27 July 2009

CHURCH FIELD, EAST PRESTON – EP/90/09

Open space and play facilities

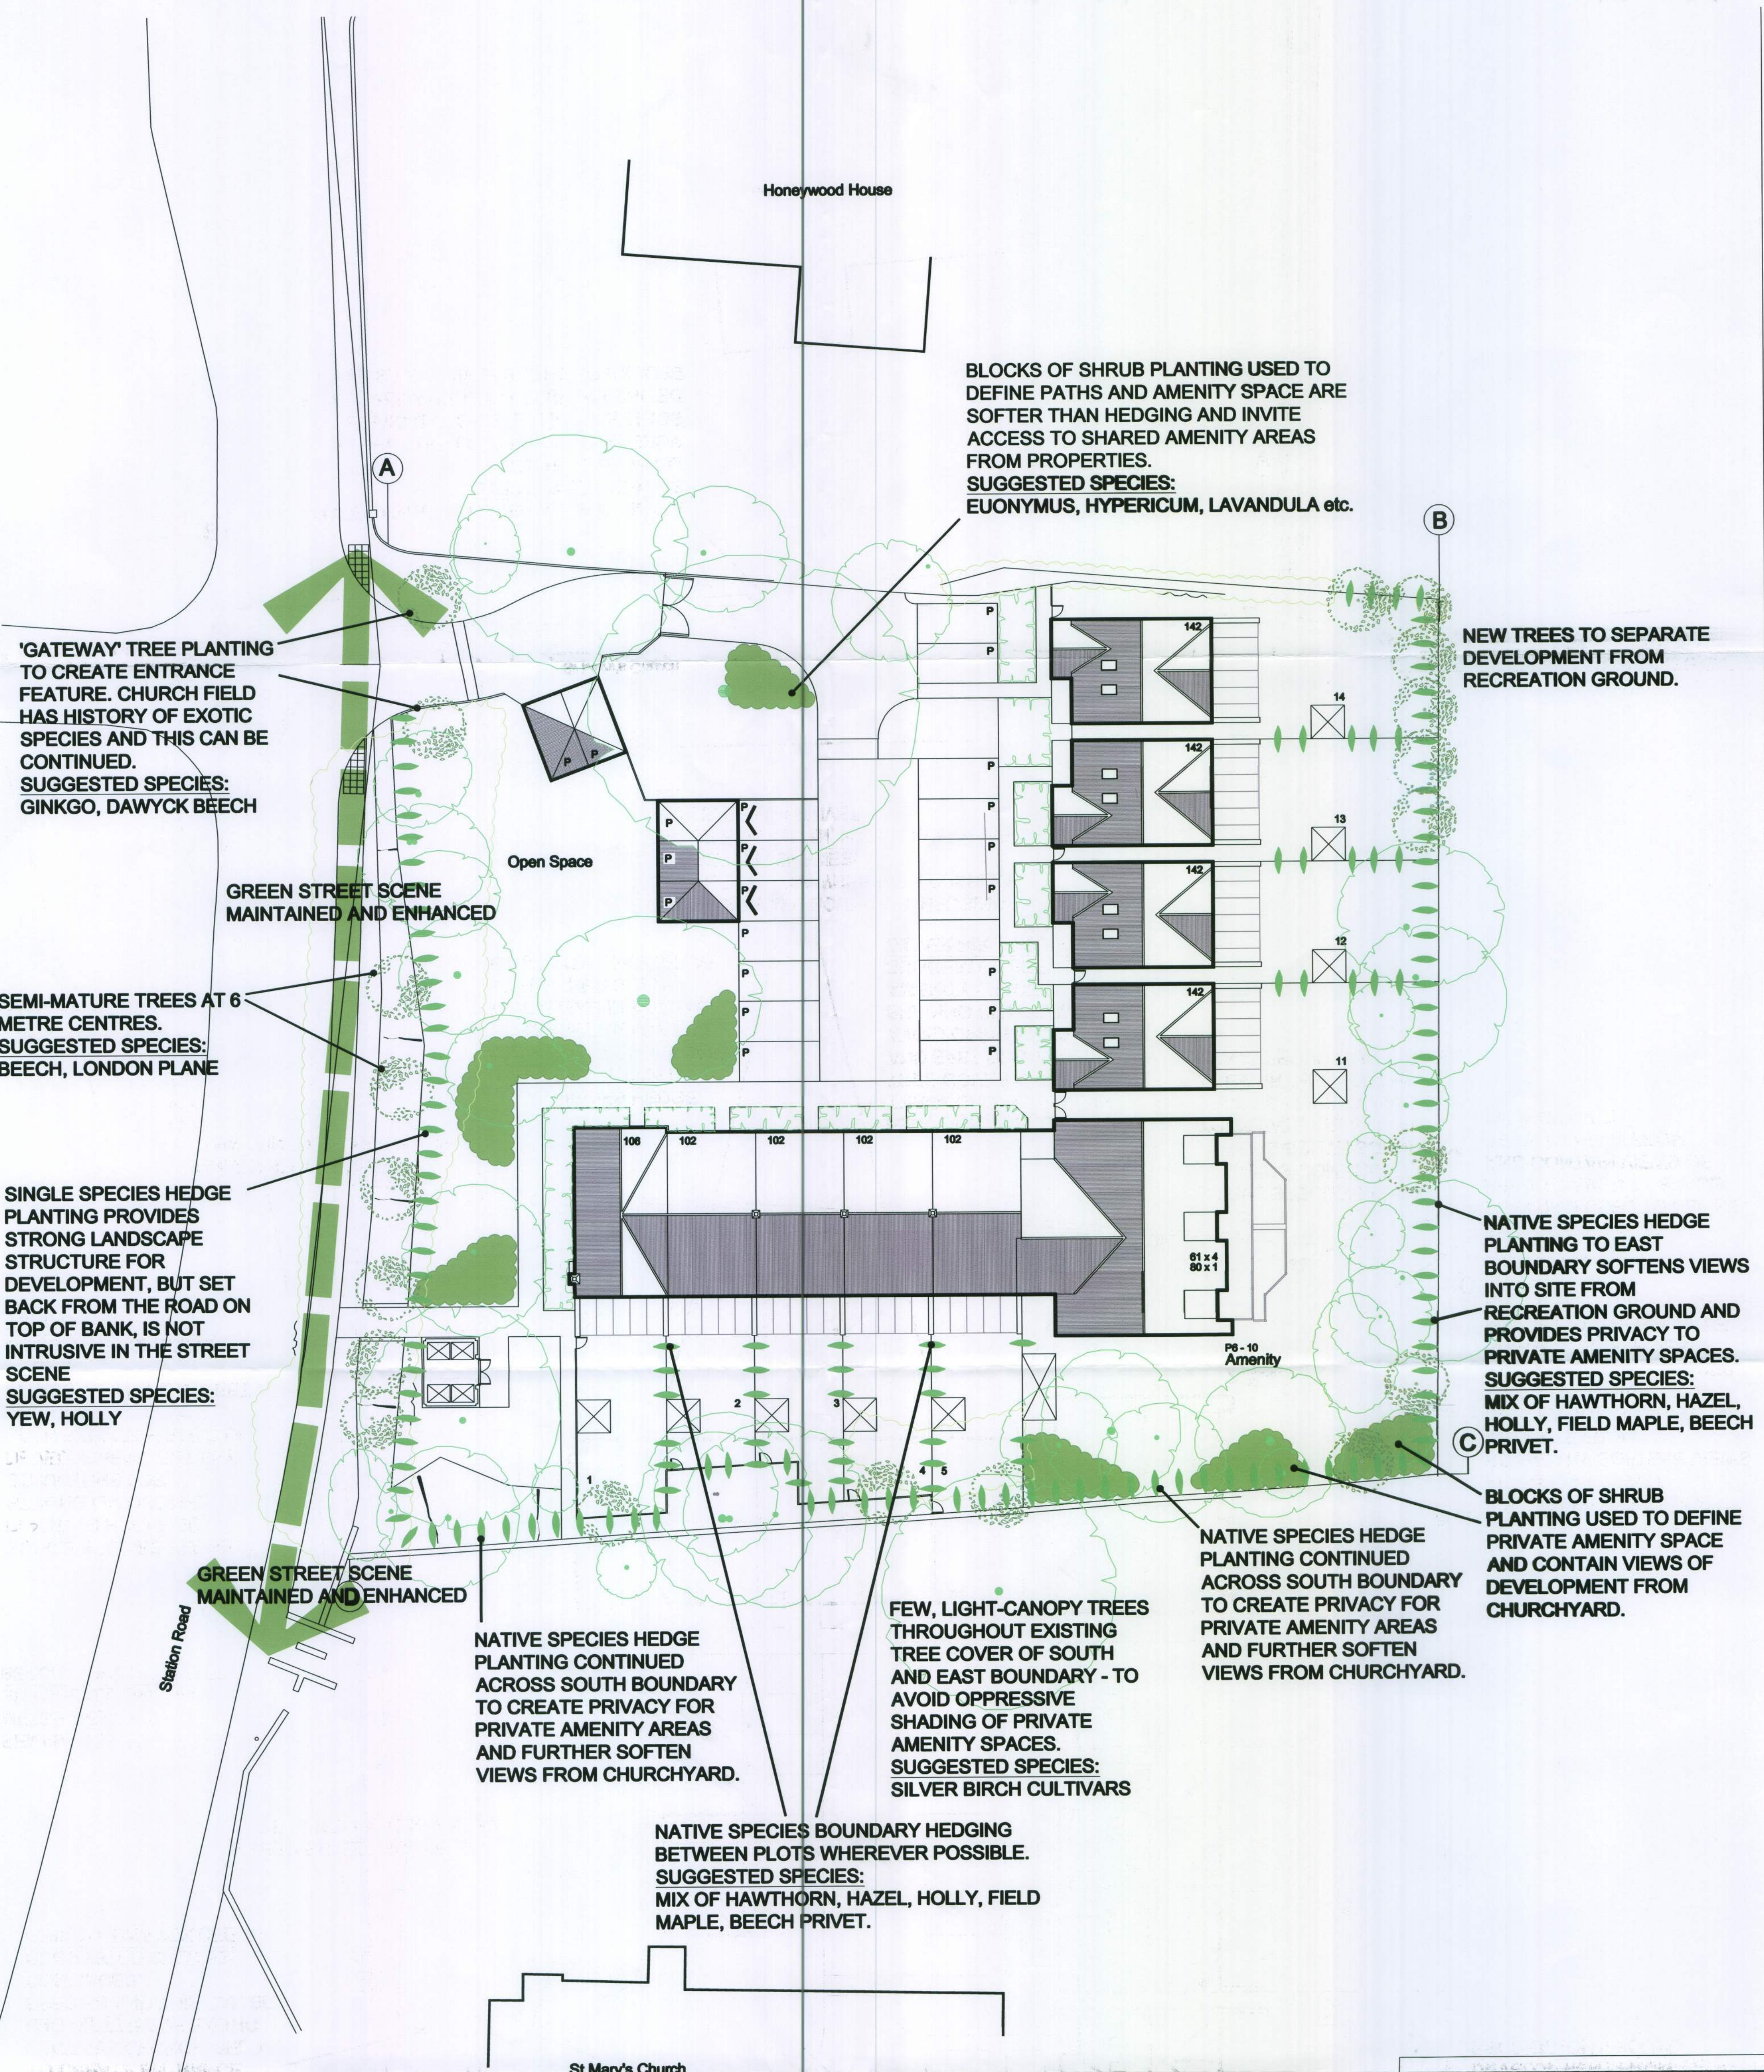
An indicative landscape strategy drawing for the development is provided on dwg 1079/09/1. However a detailed landscape plan will need to be conditioned with any permission.
